Planning Application No: 3/2024/0324

Proposal: Conversion of attached garage to office/snug and utility room.

Location: 41 Blakewater Road Clitheroe BB7 2FS

A303  
EXISTING &  
PROPOSED GF  
PLAN

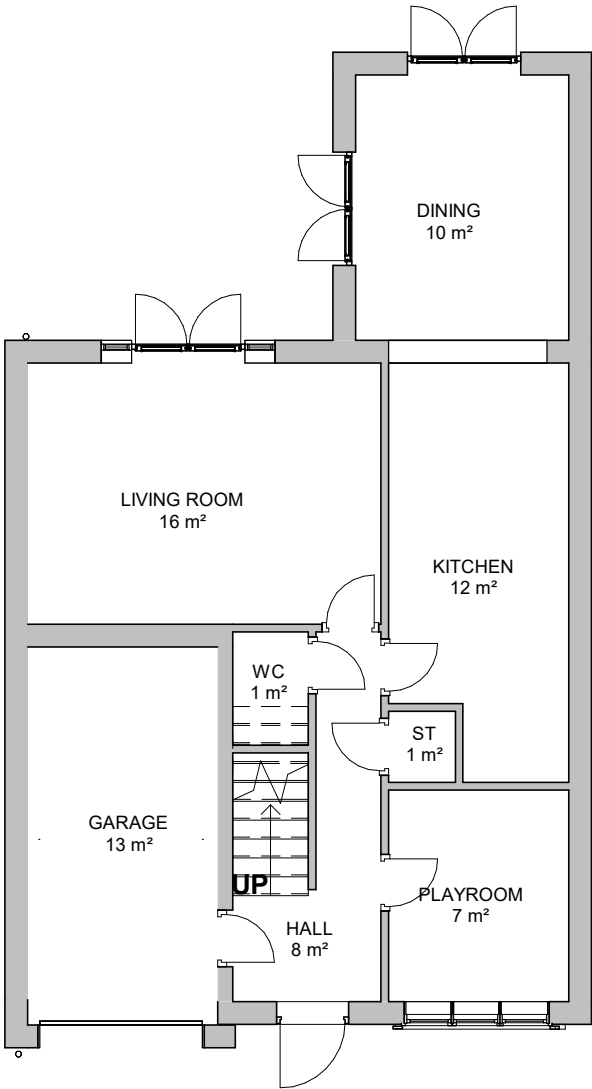
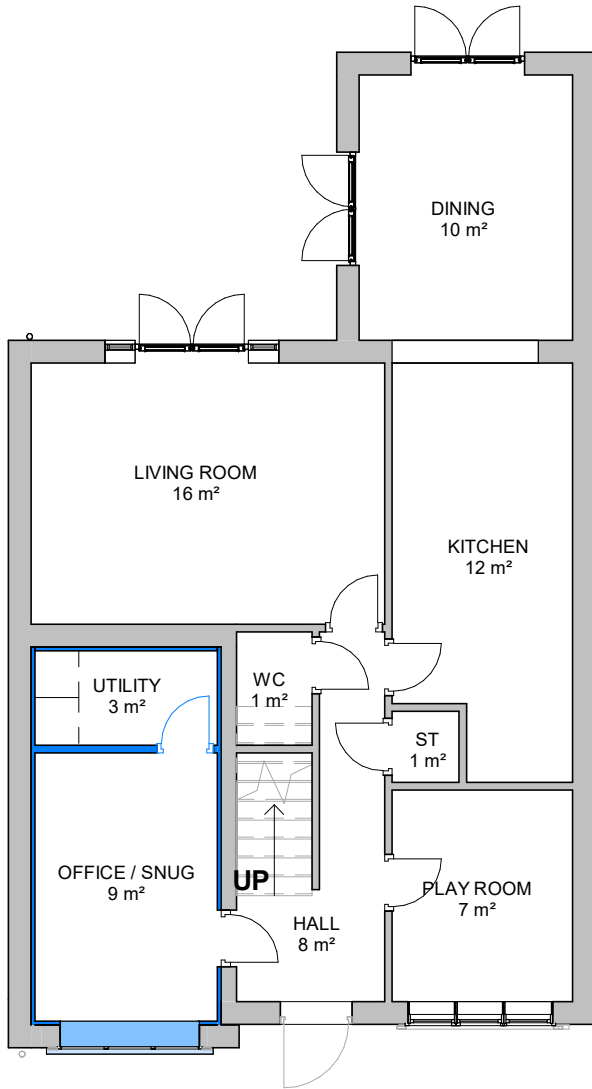
It is noted that there is a loss of a garage with this proposal. 2 parking spaces are proposed. No information on the number of bedrooms for the proposal has been provided with the submitted information. If the proposal meets parking standard requirements, then there is no objection to the proposal on highway grounds.
